RMS Reference: SYD14/01251/09 (A13302279)
DP&E Ref: SSD 6801 – MOD_1

**SECTION 96 MODIFICATION FOR PROPOSED QUARRYWEST WAREHOUSE AND
DISTRIBUTION PROJECT WITHIN GREYSTANES SOUTHERN EMPLOYMENT LANDS**

**QUARRYWEST ESTATE – REVIEW OF DESIGN REQUIREMENTS FOR PROPOSED TRAFFIC
SIGNAL CONTROLLED INTERSECTION AT RECONCILIATION ROAD/DOLERITE
CLOSE/TURNBULL CLOSE, PEMULWUY**

FIGURE 6
QUARRY WEST ESTATE
RECONCILIATION RD, PEMULWUY
CONCEPT INTERSECTION LAYOUT
RECONCILIATION RD, DOLERITE CL & TURNBULL CL
JOB NO.14136

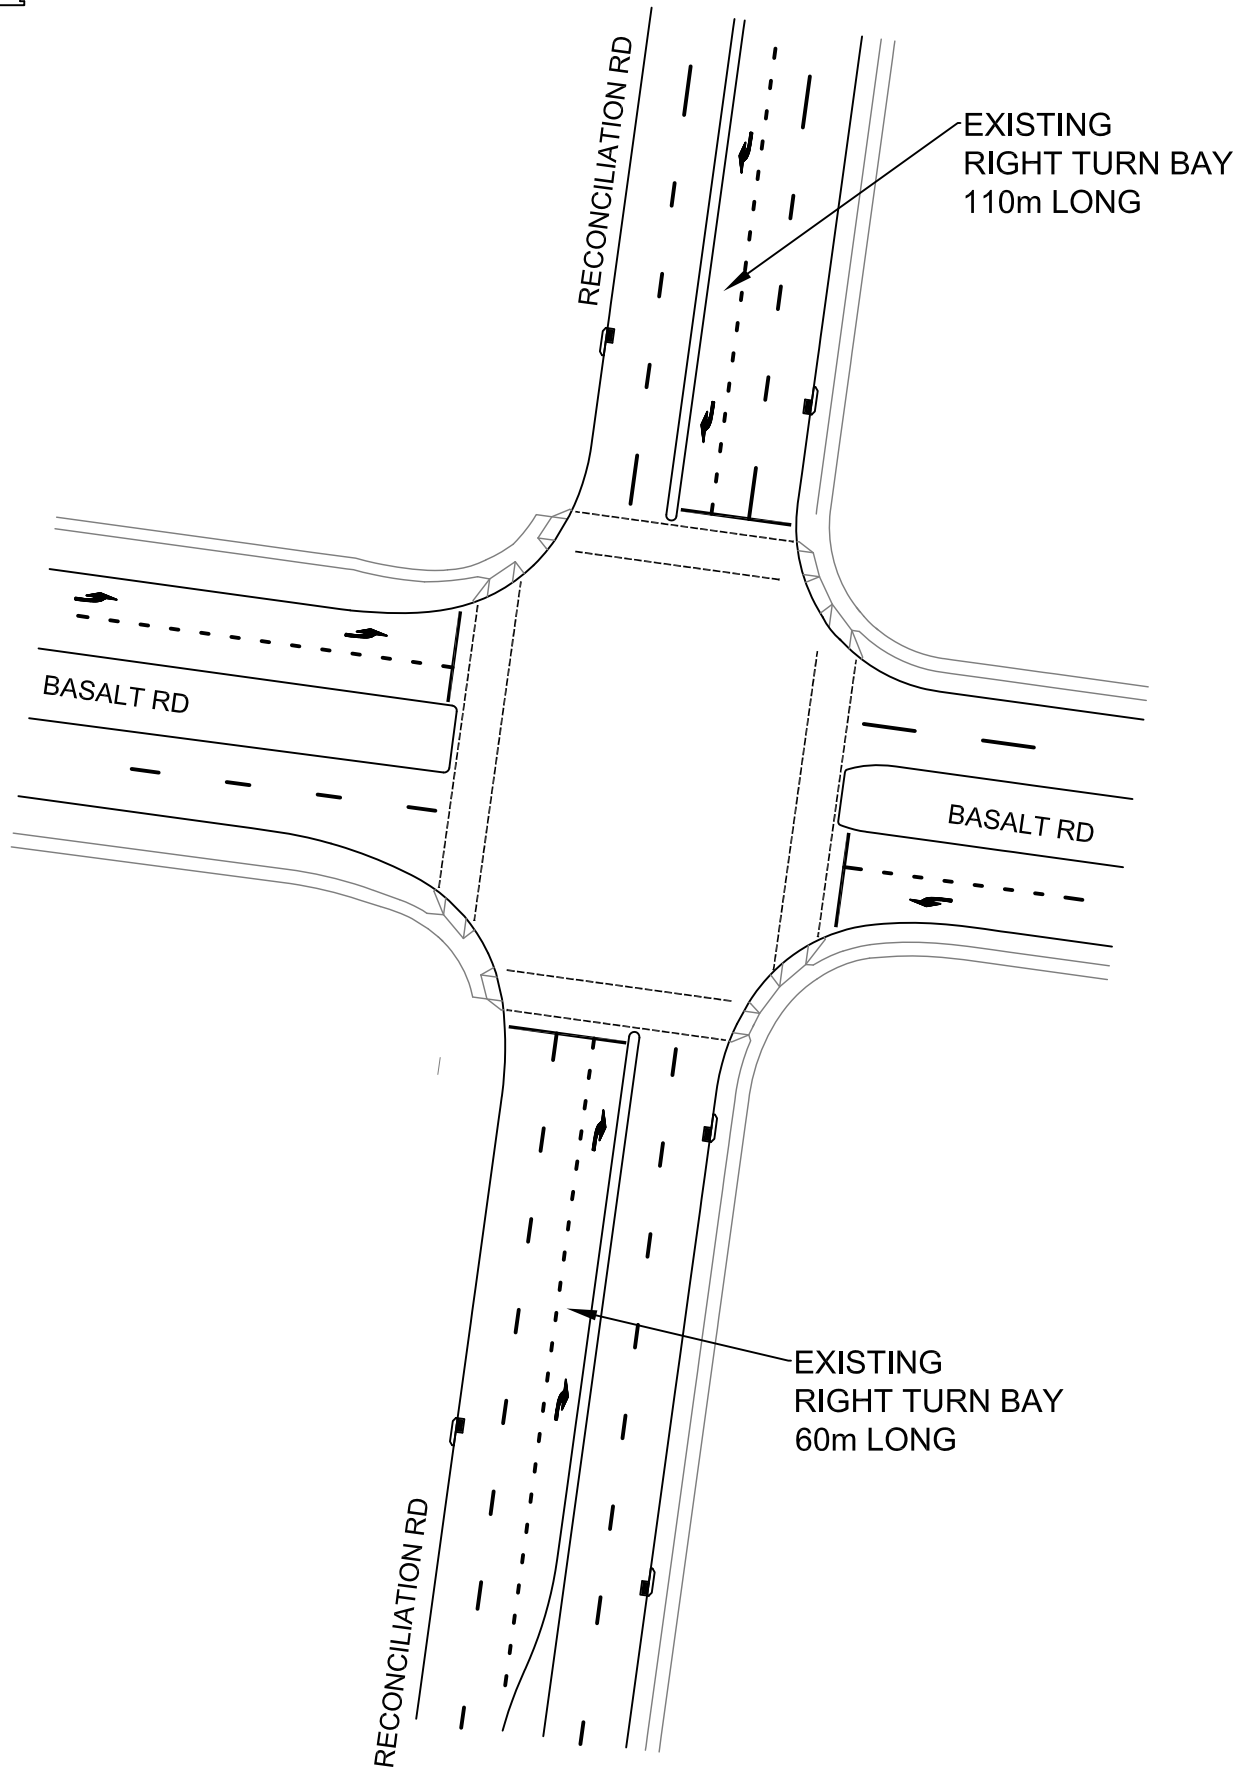
Roads and Maritime has reviewed the submitted documentation and would reiterate the comment provided in the previous letter dated 27 July 2015. The proposed 100m right turn bay from Reconciliation Drive to Dolerite close shall be amended to two right turn bays of 50 metres in length. Condition C3 and C4 from the approved Development Consent Condition (dated 20 October 2015) shall be met for the proposed development.
